# Gatwick Airport Northern Runway Project

Statement of Common Ground Between Gatwick Airport Limited and Tandridge District Council – Clean Version

DATE: JUNE 2024

Application Document Ref: 10.1.9

Diagram 3.3.1: Model performance before and after adjustment, Generic zone

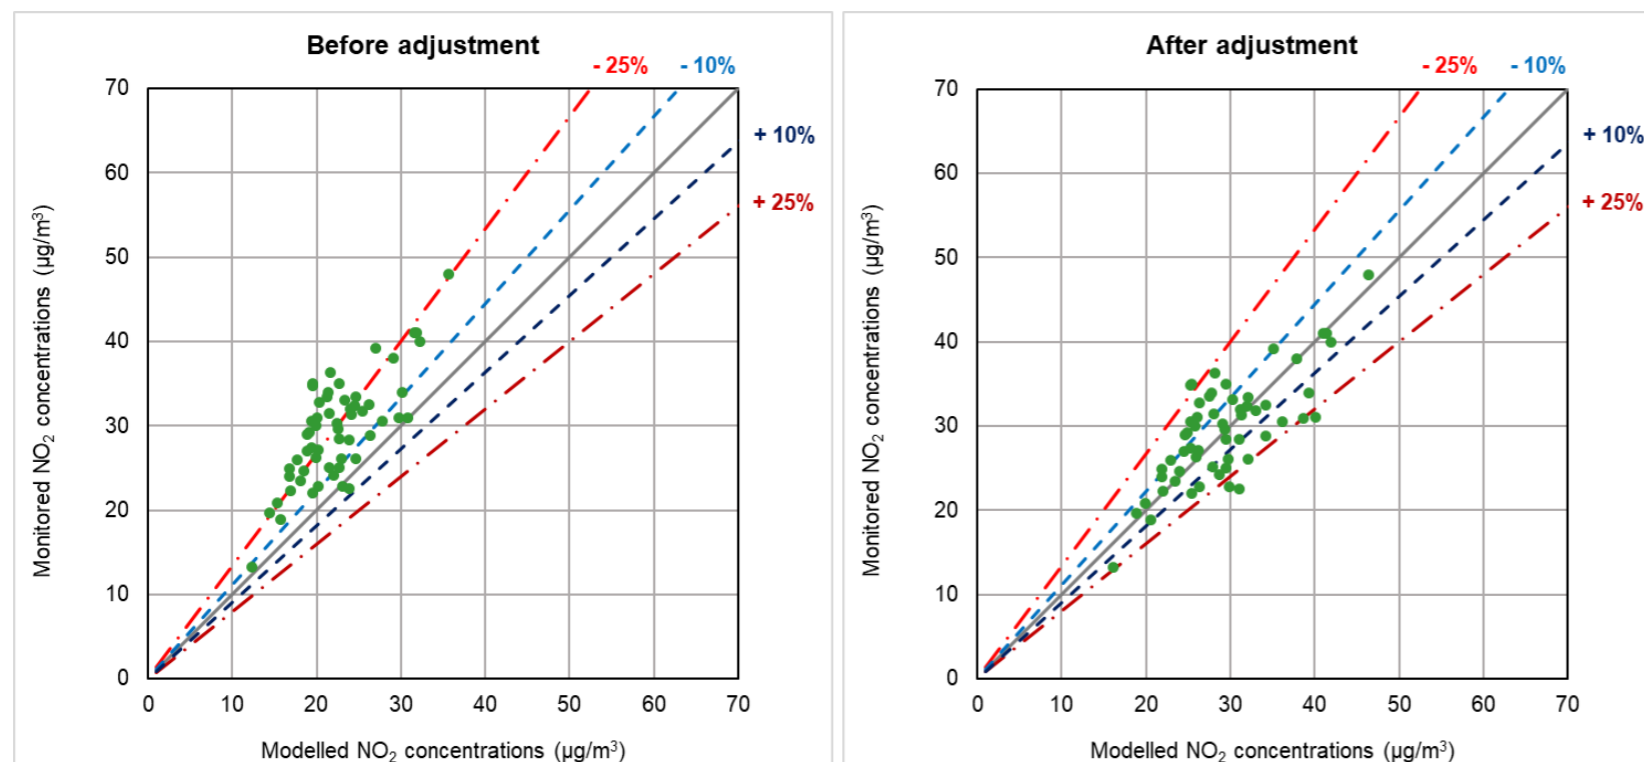
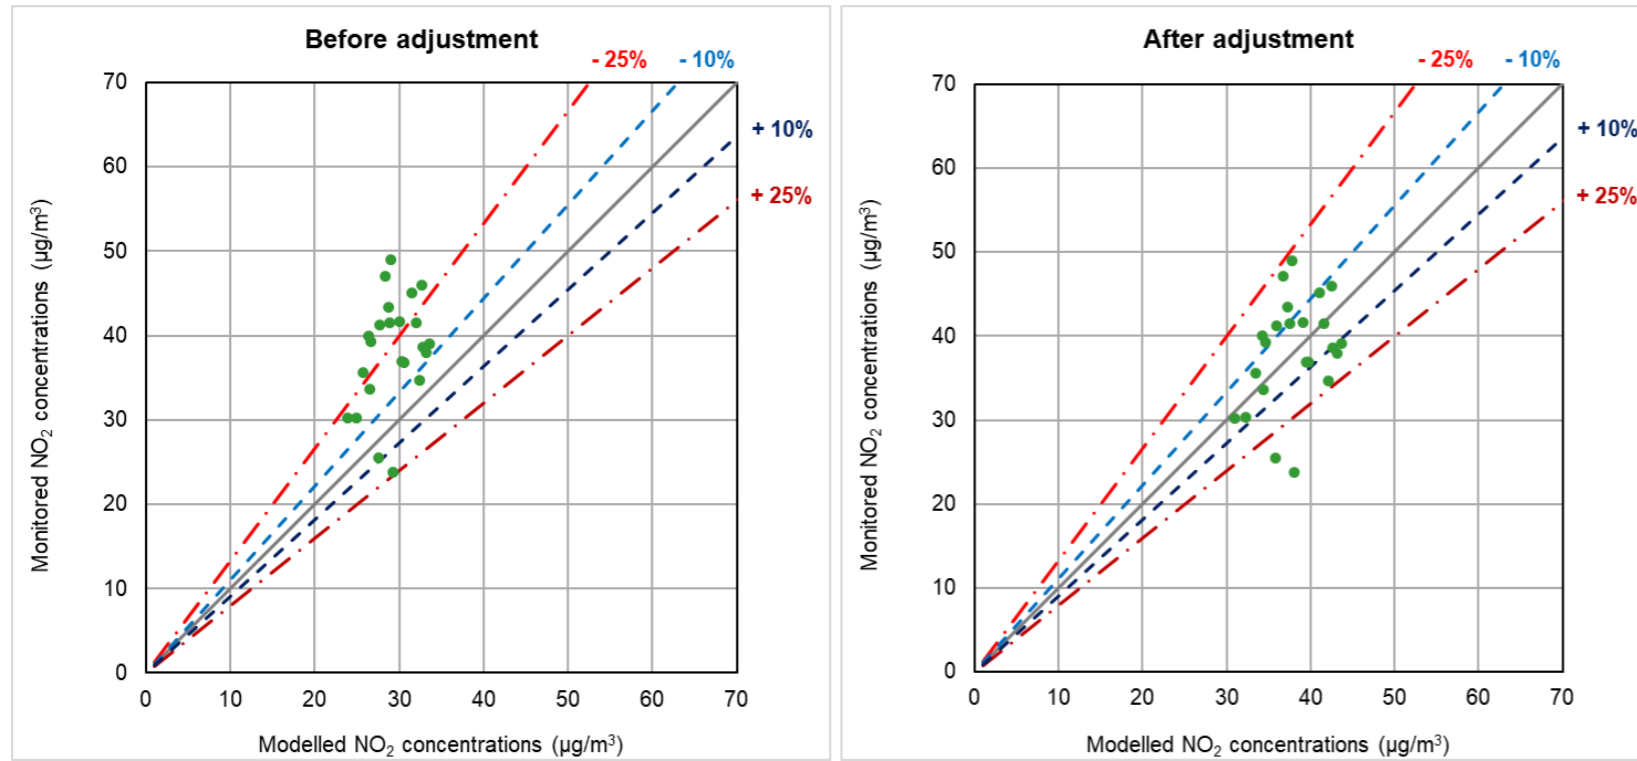
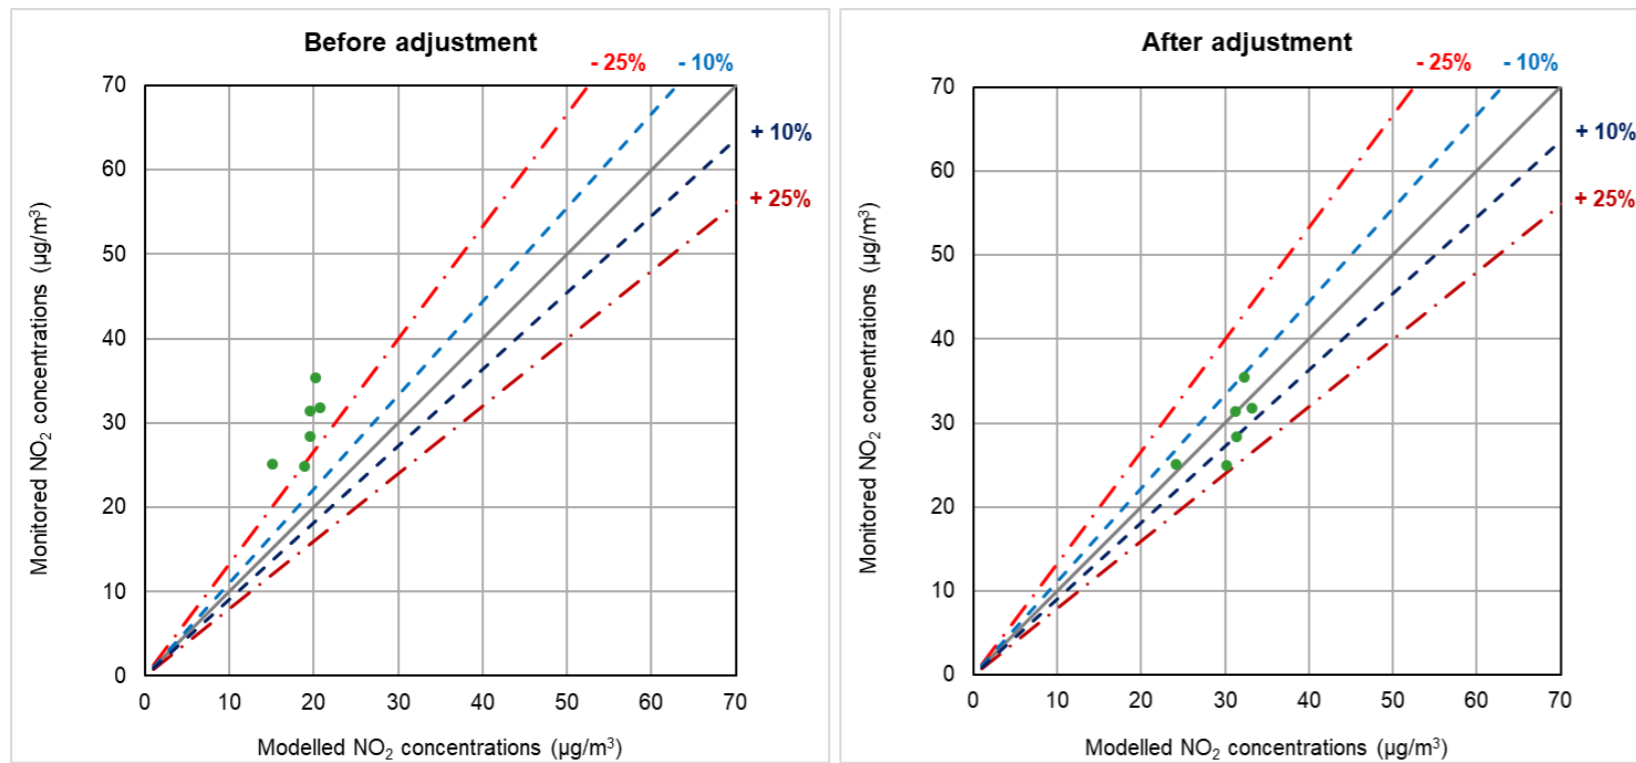
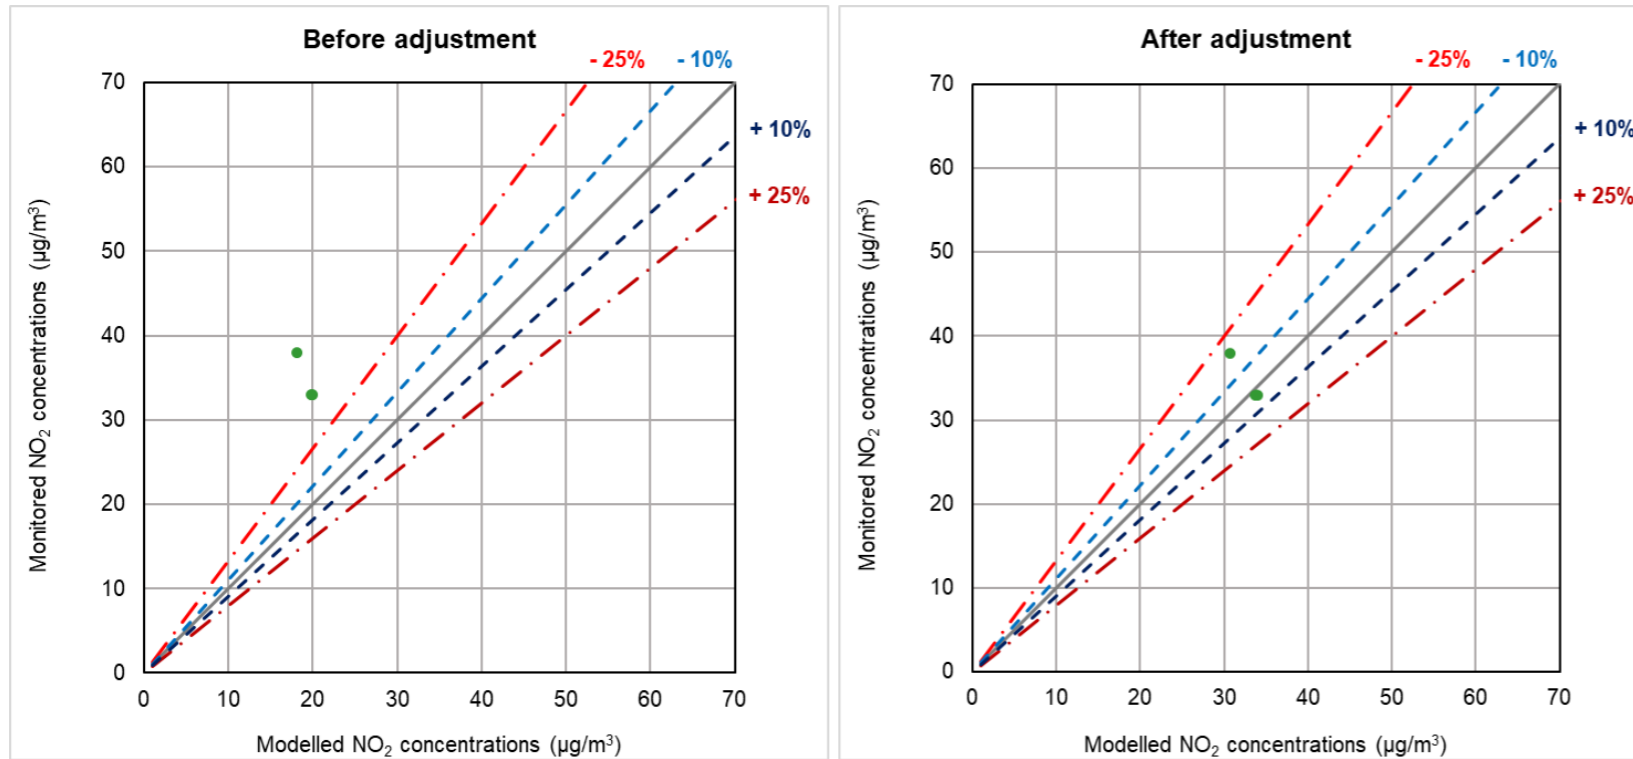
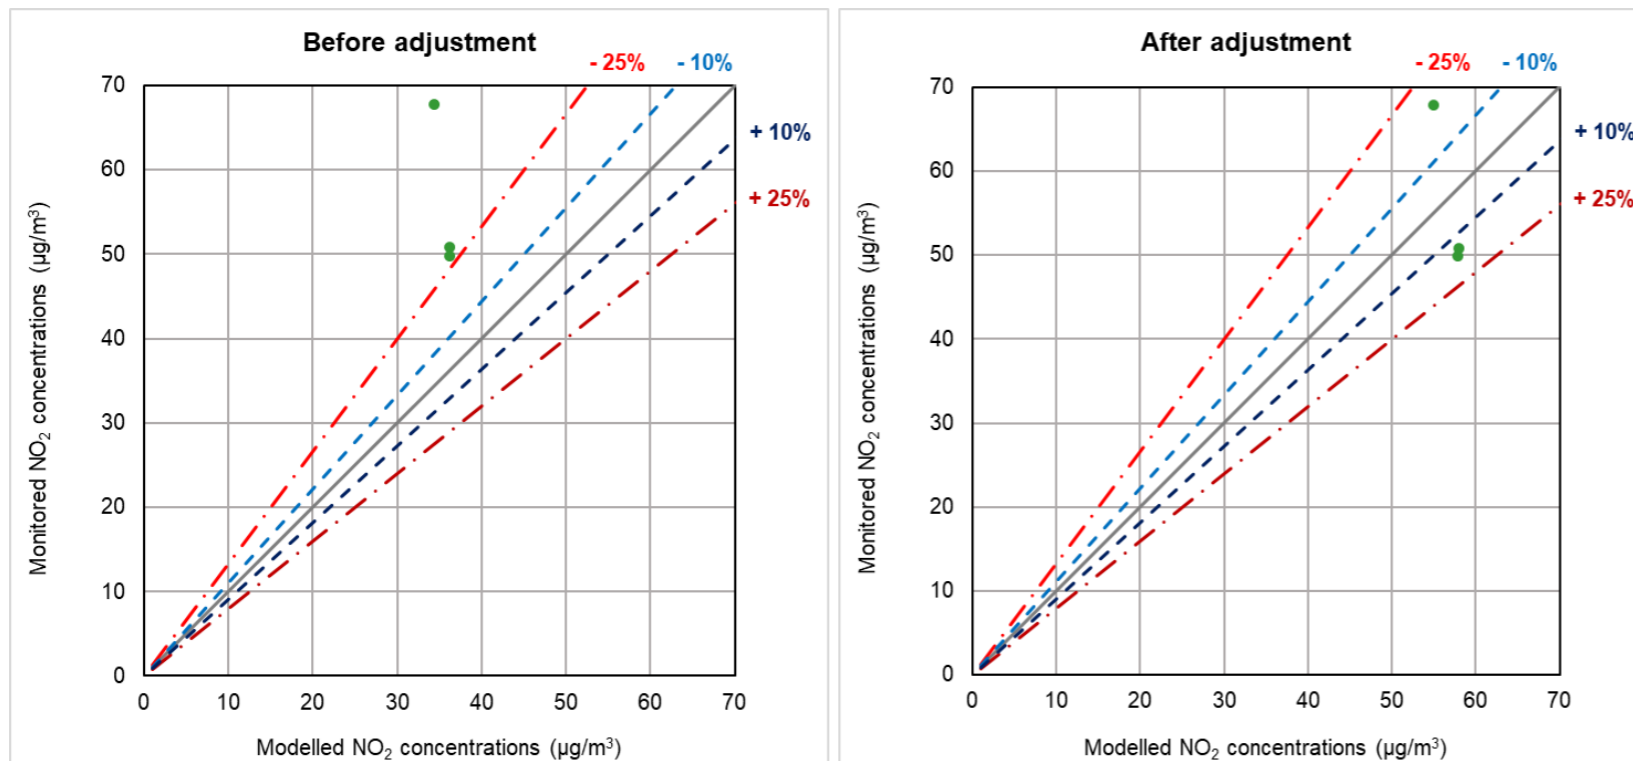
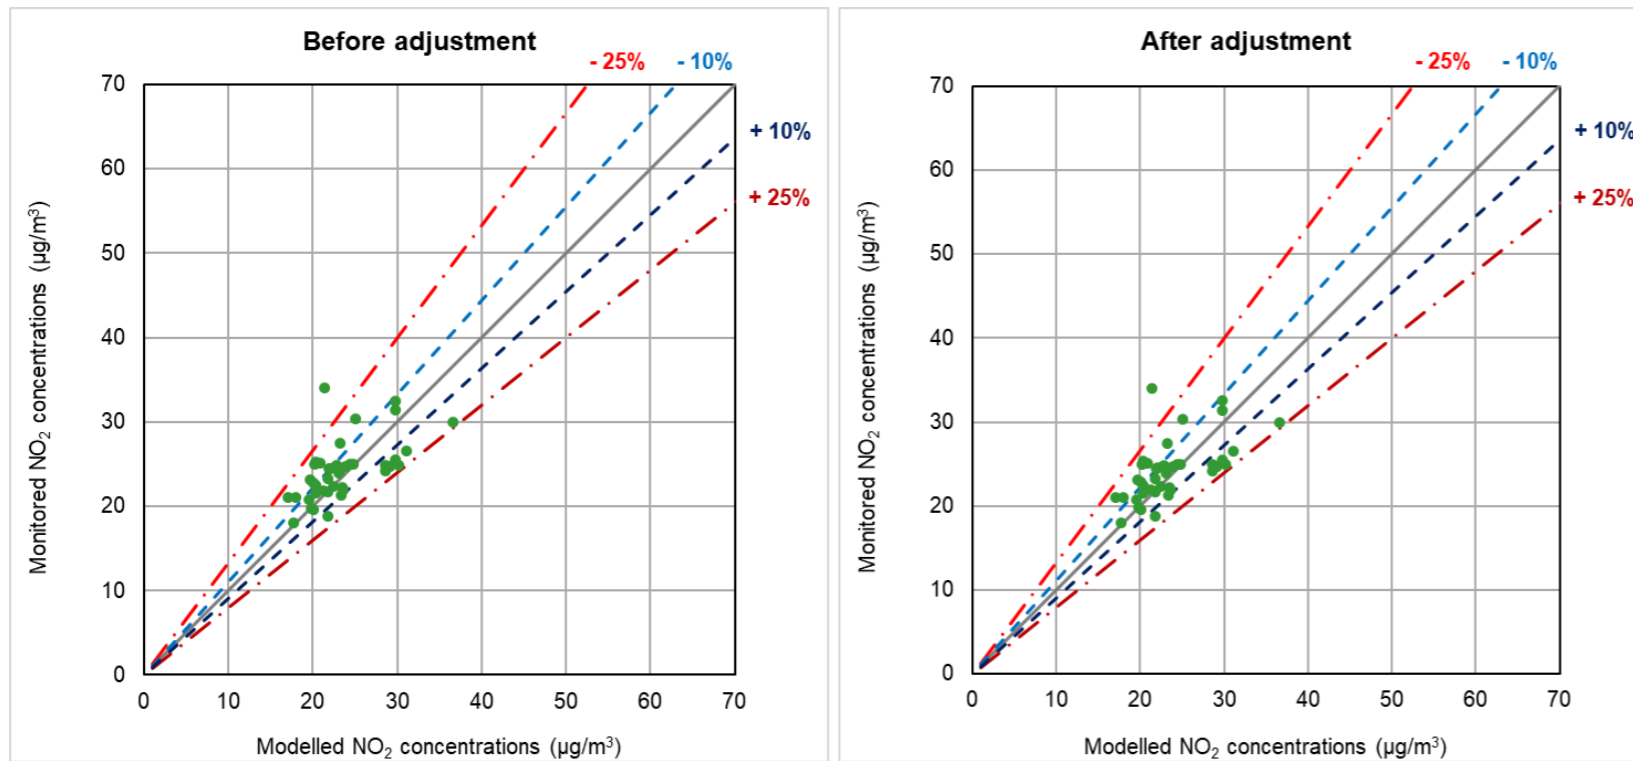
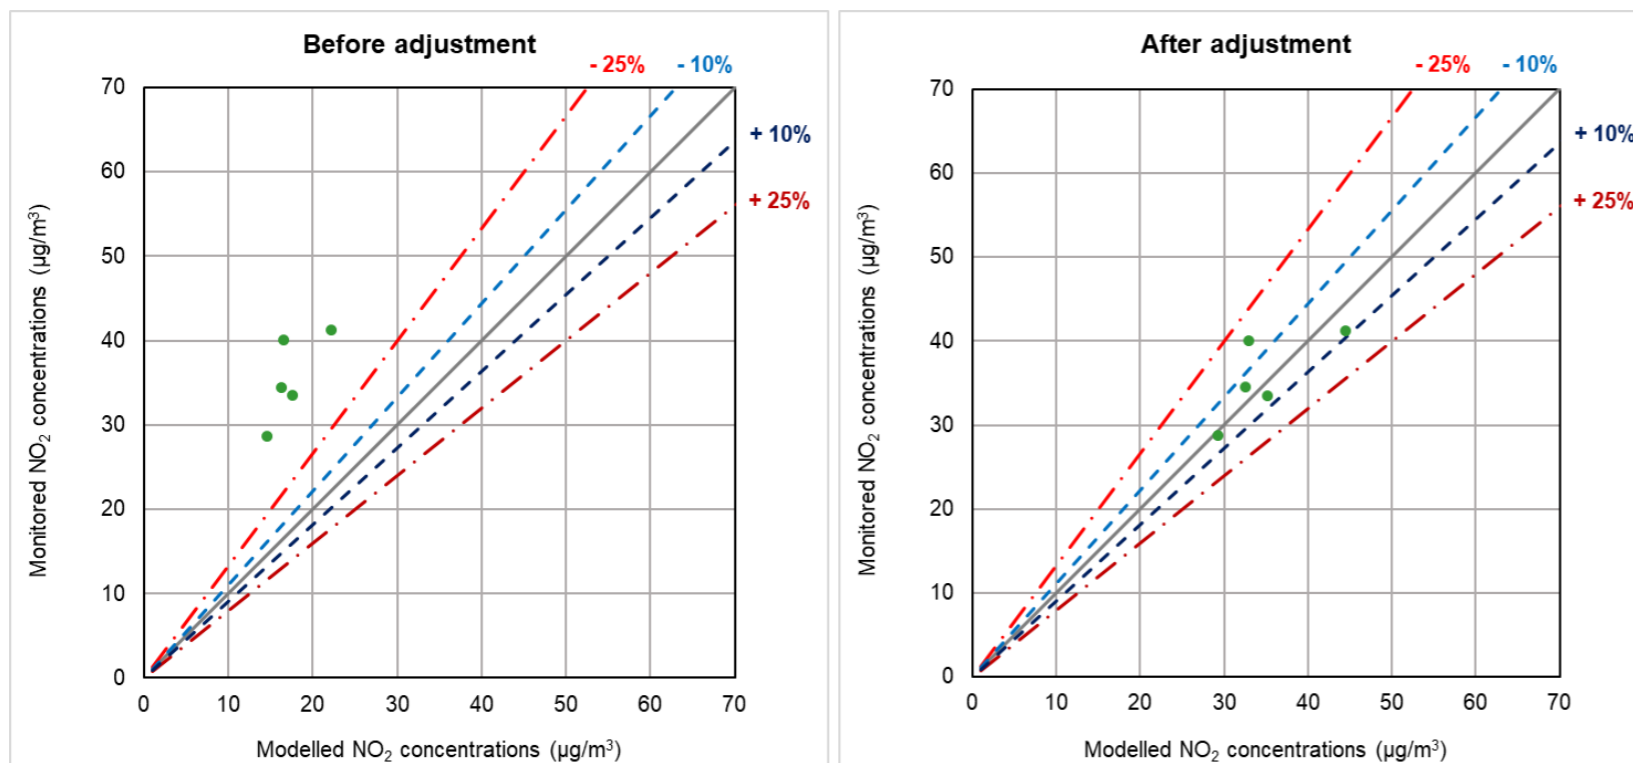
2.2.2.5	Verification zones	<p>TDC disagrees that enough justification was provided for the selection of different verification zones and why the model would be expected to perform differently in each area. A sensitivity test is required to demonstrate that the conclusions of the assessment would not change if a single verification factor were used.</p>	<p>Full details of the model verification process are included in Section 3 within the ES Appendix 13.6.1. Table 3.3.1 provides details on the verification zones used.</p>	<p><b>ES Appendix 13.6.1 Air quality Data and Model Verification</b> [APP-159],</p>	Under discussion

<p><b>Updated position (Deadline 1):</b> Further discussion is required on this point and the request for a sensitivity test examining the use of a single verification factor still remains.</p> <p><b>Updated position (Deadline 5):</b> Gatwick Airport Limited (GAL) comments in paragraph 3.7.7 of their Response to Deadline 3 Submissions [REP4-031] that the air quality matters submitted by the Joint Local Authorities at Deadline 3 (Appendix A) [REP3-117] will be responded to by Deadline 5. This Appendix of air quality queries prepared by AECOM included a wide range of technical matters.</p>	<p>The verification methodology was agreed with local councils at the modelling methodology workshop in November 2022. Model files and results were provided to the TWG via email 18<sup>th</sup> August 2023.</p> <p>The process followed during the ES took into account feedback from the local authorities at the PEIR stage and following discussions on the agreed approach.</p> <p><b>Updated position (April 2024):</b> The Applicant notes that the JLAs have provided a submission on air quality at Deadline 3. The Applicant will review this submission and respond accordingly.</p> <p><b>Updated position (Deadline 5):</b> The Applicant has provided a response to the air quality matter submitted by the JLAs at <b>Appendix A: Response to West Sussex Joint Local Authorities – Air Quality to The Applicant’s Response to Deadline 4 Submissions</b> (Doc Ref. 10.38). The Applicant will respond at Deadline 6 to the JLAs’ review submitted at Deadline 4 [REP4-053].</p>	<p><b>Appendix A: Response to West Sussex Joint Local Authorities – Air Quality to The Applicant’s Response to Deadline 4 Submissions</b> (Doc Ref. 10.38)</p>
